**APPENDIX 3 to Deadline 3 Overview – REP3-xxx**

**RHS response to REP2-022 Deadline 2 Submission - 9.27 Applicant's Response to RHS comments on Air Quality**

Figure 4.1: Location of additional receptors in Ripley

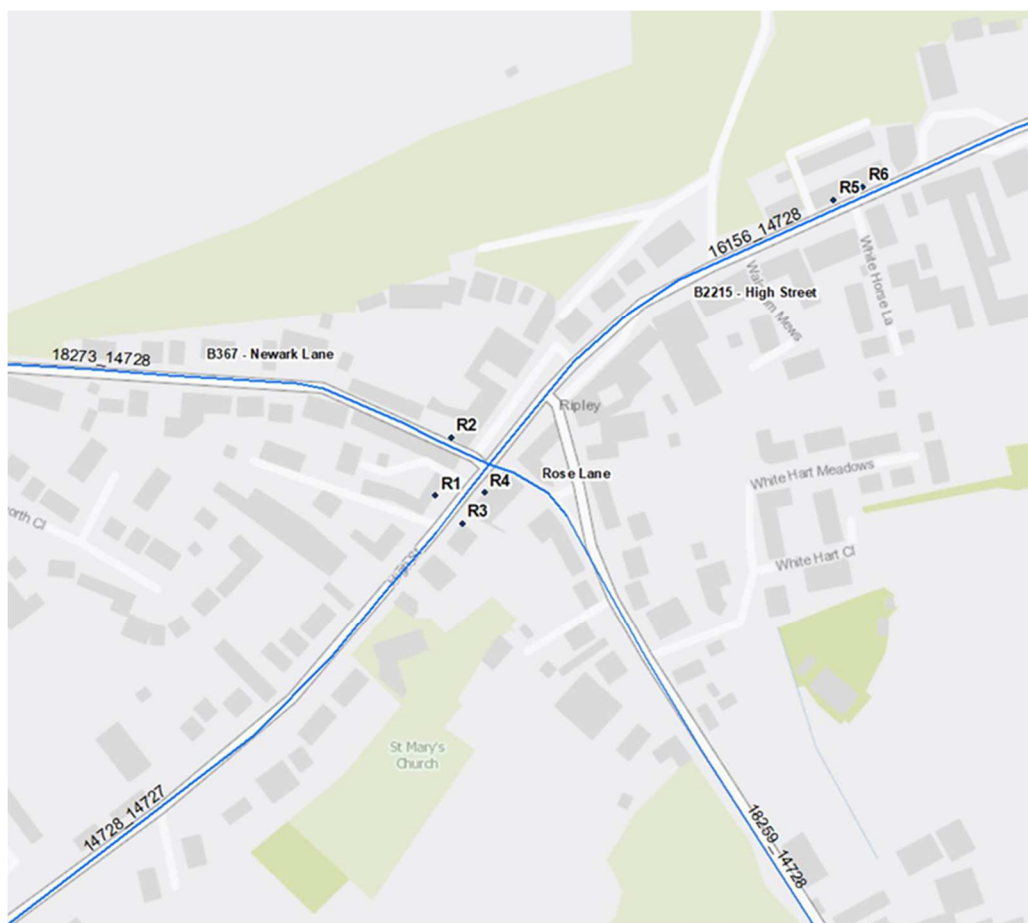
Receptor ID	X	Y	2015 Base Year	2022 DM	2022 DS	Change	R1	505144	156717	15.2	12.2	12.6	0.4	R2	505152	156747	18.3	14.9	15.3	0.4	R3	505158	156702	17.2	13.9	14.5	0.6	R4	505170	156718	18.3	14.9	15.5	0.6	R5	505353	156872	19.0	15.9	16.7	0.8	R6	505368	156879	19.1	15.9	16.8	0.9	<p>Something is seriously wrong with the HE’s modelling in Ripley. The modelled 2015 NO<sub>2</sub> concentrations, which are now all close to the edge of the road, are all less than 20 µg/m<sup>3</sup>. The measured concentrations at two locations in Ripley in 2016 were 29 and 34 µg/m<sup>3</sup>. The modelling is clearly grossly under-estimating the concentrations. The model should be verified and adjusted against the monitoring data, which has not been done. If the model is underestimating, then this will also apply to the changes in concentrations with the DCO Scheme. This underestimation is probably by a factor of around 2. Thus, a change of 0.9 µg/m<sup>3</sup> with the Scheme (at R6) would become a change of 1.8 µg/m<sup>3</sup>, which is a 4.5% increase (in relation to the objective of 40 µg/m<sup>3</sup>). Very different from the 0.4 µg/m<sup>3</sup> or 1% increase shown for receptor R59 in the ES (Table 5.7.9 in APP-080, page 63).</p> <p>The new assessment of impacts in Ripley should not be relied upon by the ExA.</p>
Receptor ID	X	Y	2015 Base Year	2022 DM	2022 DS	Change																																												
R1	505144	156717	15.2	12.2	12.6	0.4																																												
R2	505152	156747	18.3	14.9	15.3	0.4																																												
R3	505158	156702	17.2	13.9	14.5	0.6																																												
R4	505170	156718	18.3	14.9	15.5	0.6																																												
R5	505353	156872	19.0	15.9	16.7	0.8																																												
R6	505368	156879	19.1	15.9	16.8	0.9																																												
<p>4.2.3 These changes are based on traffic data from design fix 2 (DF2) which as documented in paragraph 5.5.12 of APP-050 were used as the basis for the air quality assessment, given that DF2 traffic data would provide more conservative results than the revised DF3 data, as a result of the changes in traffic being generally larger with DF2 than with DF3.</p>	<p>Noted</p>																																																	
<p>4.2.4 The change in traffic through Ripley with DF3 is markedly lower, with an expected increase in annual average daily traffic (AADT) through Ripley of 1073, compared to an increase in AADT of 2535 with DF2.</p>	<p>Noted</p>

HE Response at Deadline 2 (REP2-022)	RHS Response																																																	
<p>4.2.2 However, it is acknowledged that there are other receptors in Ripley which are closer to the kerb, although not in closer proximity to the junction. Nitrogen dioxide concentrations at residential receptors in the areas identified in REP1-041 along Newark Lane and High Street, have been modelled to determine the expected changes in annual mean nitrogen dioxide concentrations with the Scheme. These additional receptors are provided in Figure 4.1, and the results provided in Table 4.1. The largest change is expected to be a change of 0.9 µg/m<sup>3</sup>, classified as a small increase, at a receptor on the High Street (R6).</p>
